From: Michael Eastham <Michael.Eastham@arun.gov.uk>
Sent: 05 August 2020 13:29
To: Planning.Responses <Planning.Responses@arun.gov.uk>
Subject: FW: LU/183/20/DOC- Land South of Toddington Lane

Please upload to Ocella the email below which is a consultation response from ADC Drainage engineers to discharge of condition application **LU/183/20/DOC- Land South of Toddington Lane**.

From: Laura Gibbons [REDACTED]
Sent: 04 August 2020 15:52
To: Planning.Responses <Planning.Responses@arun.gov.uk>
Cc: Michael Eastham <Michael.Eastham@arun.gov.uk>
Subject: LU/183/20/DOC- Land South of Toddington Lane

Drawing Title:
PROPOSED S38/S278 HIGHWAY WORKS
SOUTHERN BYPASS WORKS
LOCATION PLAN

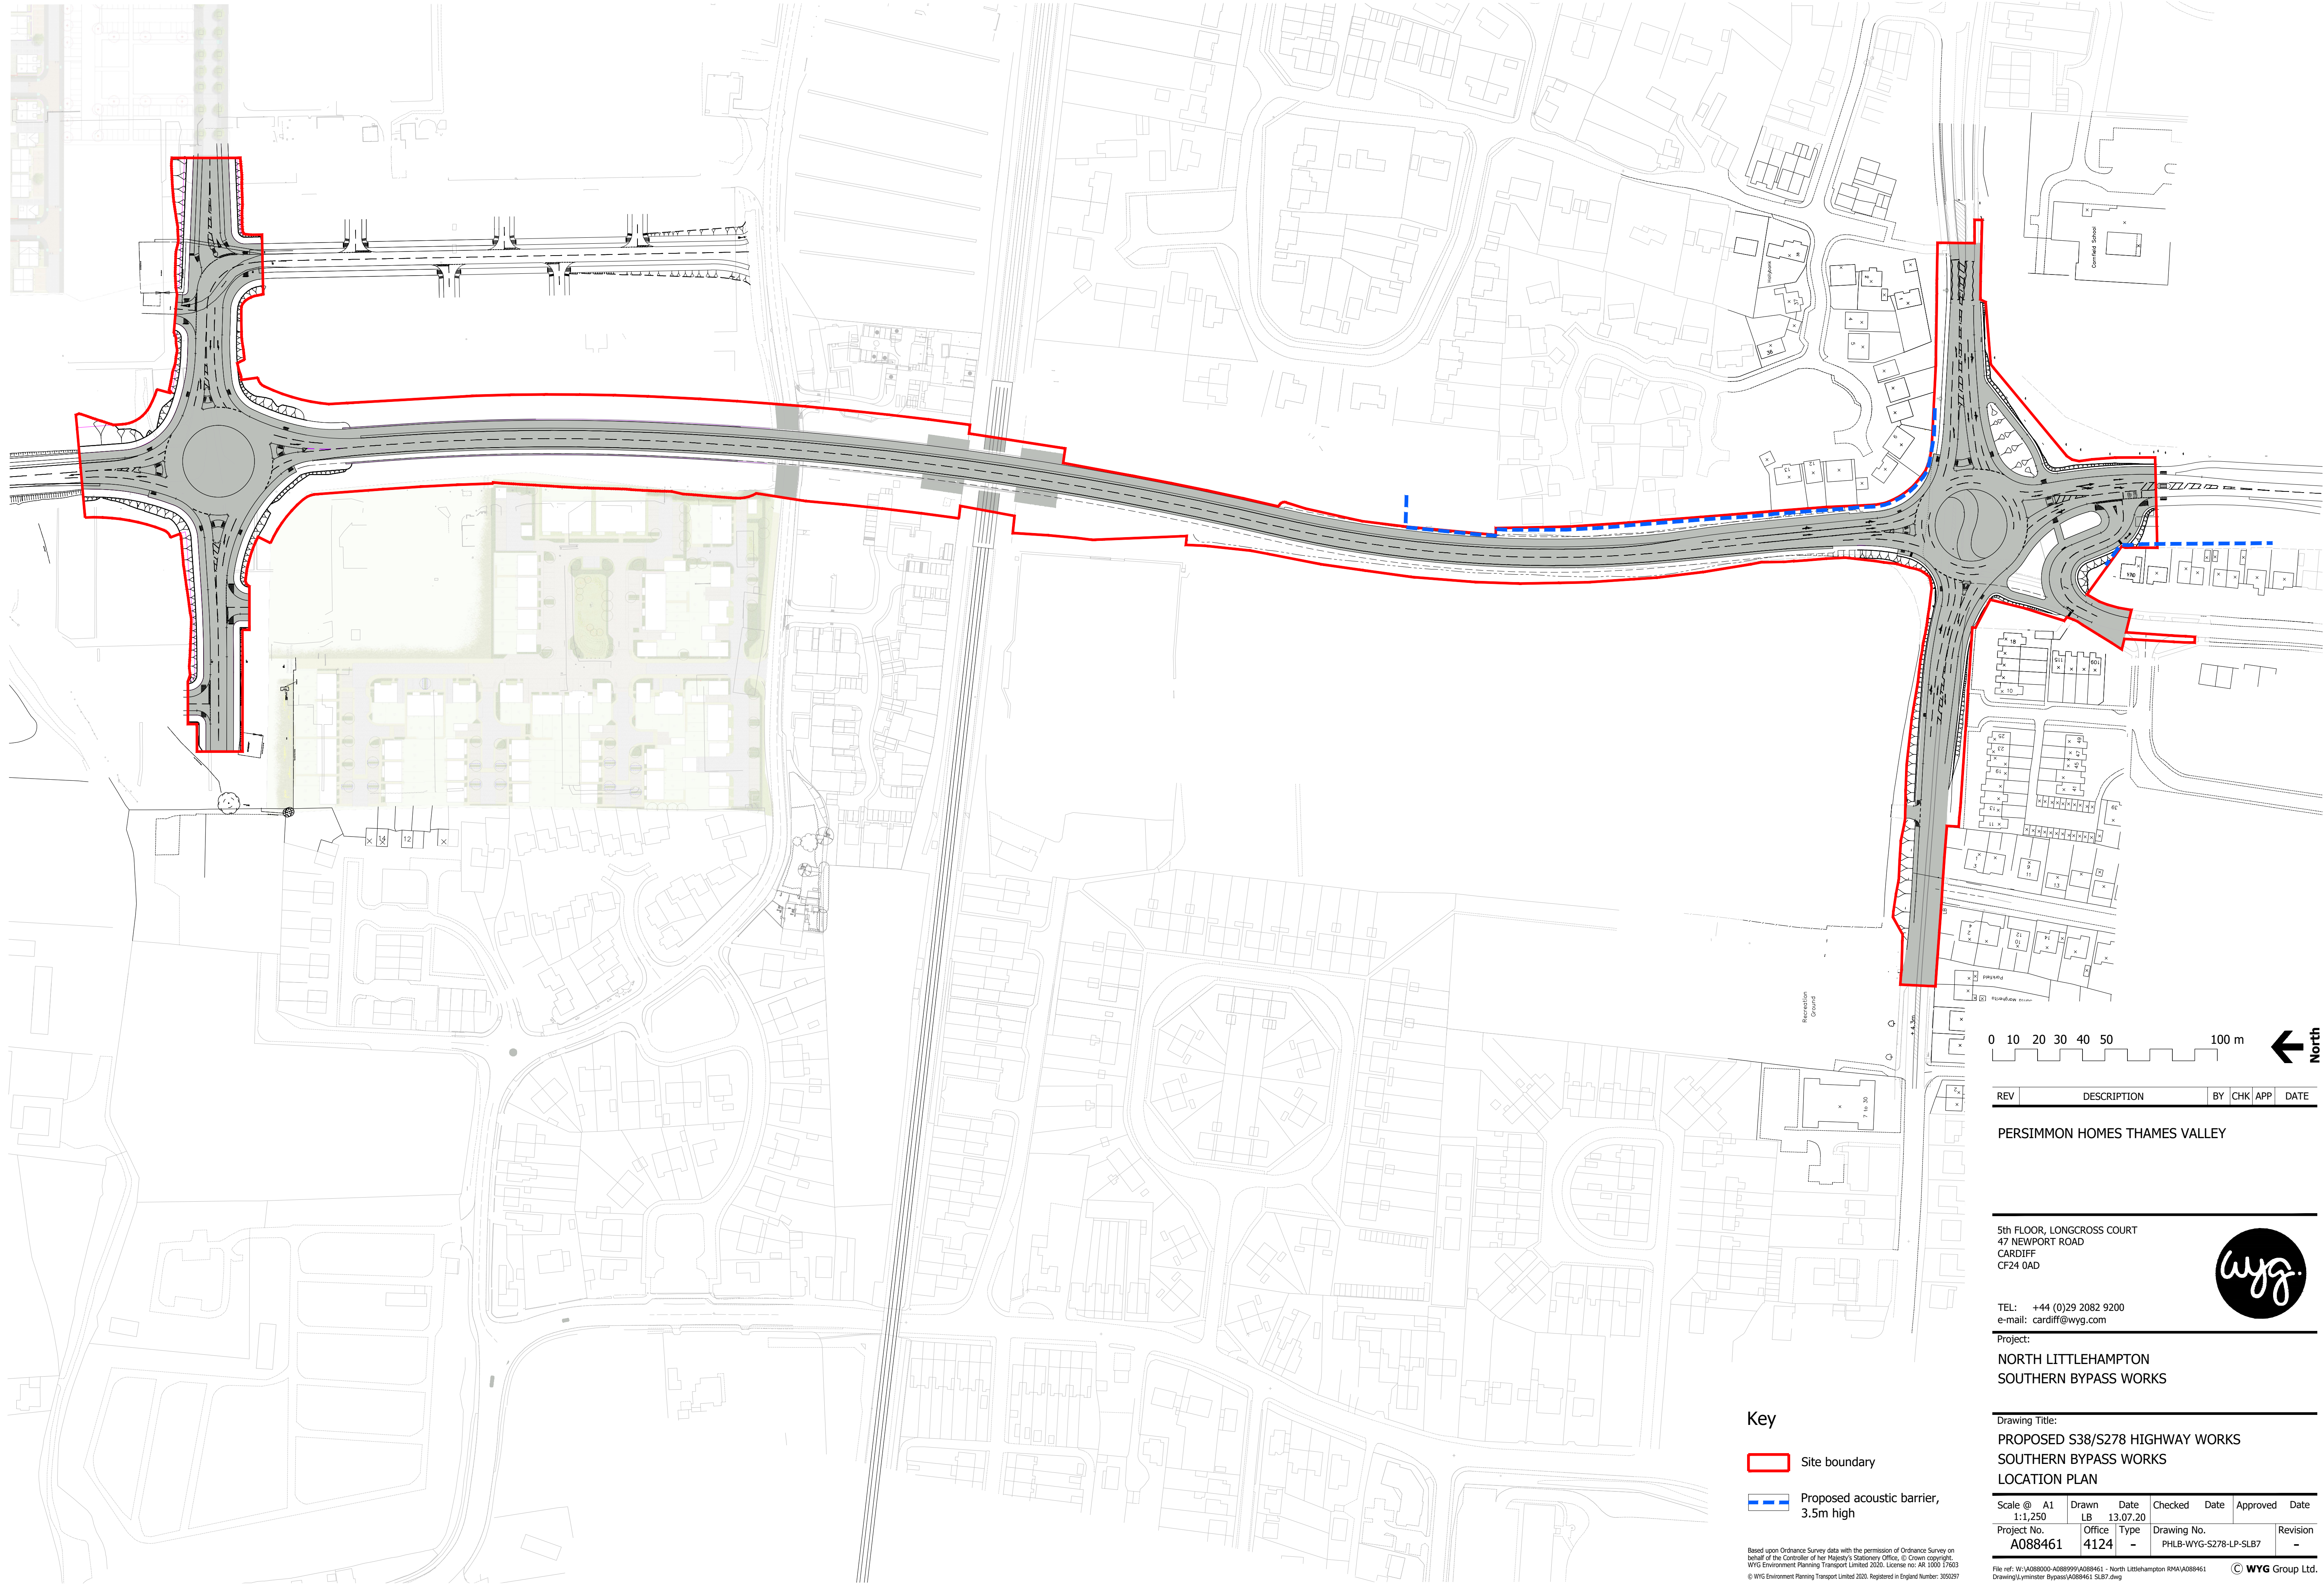
We have no comments regarding condition 36. The acoustic barrier does not appear to affect any drainage channels or surface water flow paths.
